Administrative Authorization Decision

**Appliation #:** 2013-168  
**Name:** 498 sq ft of additonal pavement  
**Address:** RIVERSIDE ST  
**Description:** 498 sq ft of additonal pavement

The Administrative Authorization for the 498 sq ft of additonal pavement was approved by Barbara Barhydt, Development Review Services Manager on August 16, 2013 with the following condition of approval listed below:

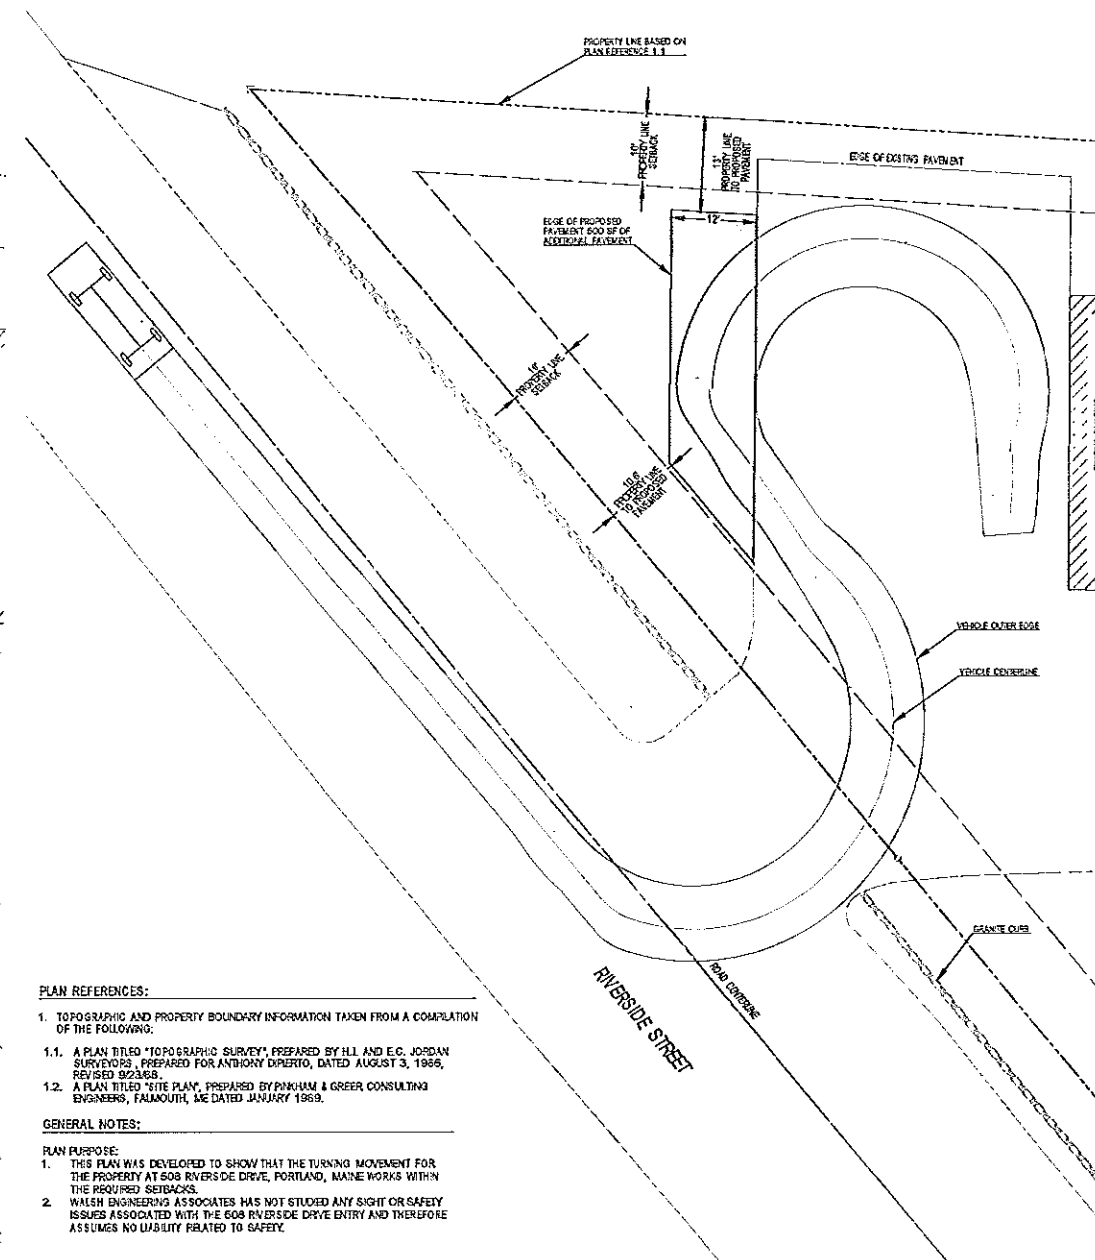
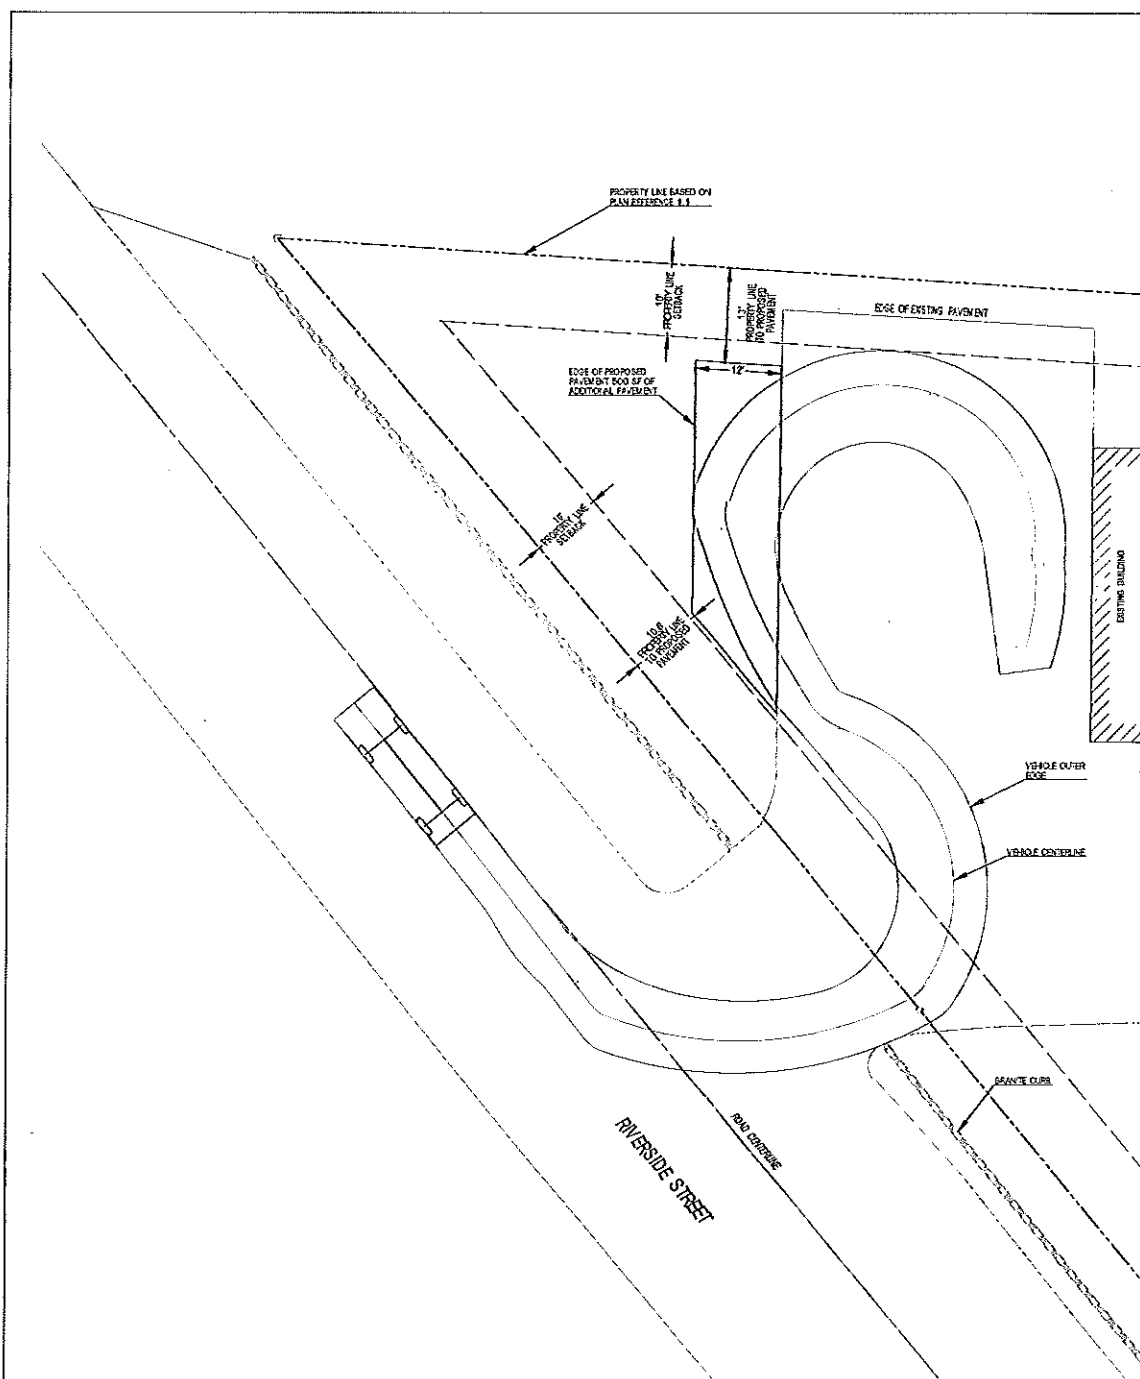
I will share this information with Tom Errico. Would you please have Bill show the edge of the proposed pavement, the distances of the proposed pavement from the property line, and the amount of square footage of pavement that is being added.

- 1) On August 15, 2013, Tom Errico, Consulting Traffic Engineer, found the plans for the traffic cirulation shown on-site for the plans prepared by Bill Walsh (dated C.1.0, August 2013) to be acceptable.
- 2) The request for an administrative authorization for the 500 square foot expansion of pavement, as shown on the site plan, is approved with two conditions:
  - 1) The pavement shall be installed as shown on the site plan prepared by Bill Walsh (August 2013, C.1.0), which confirms the setbacks from property lines and area of pavement; and
  - 2) Obtain all required permits from the Inspection Division.
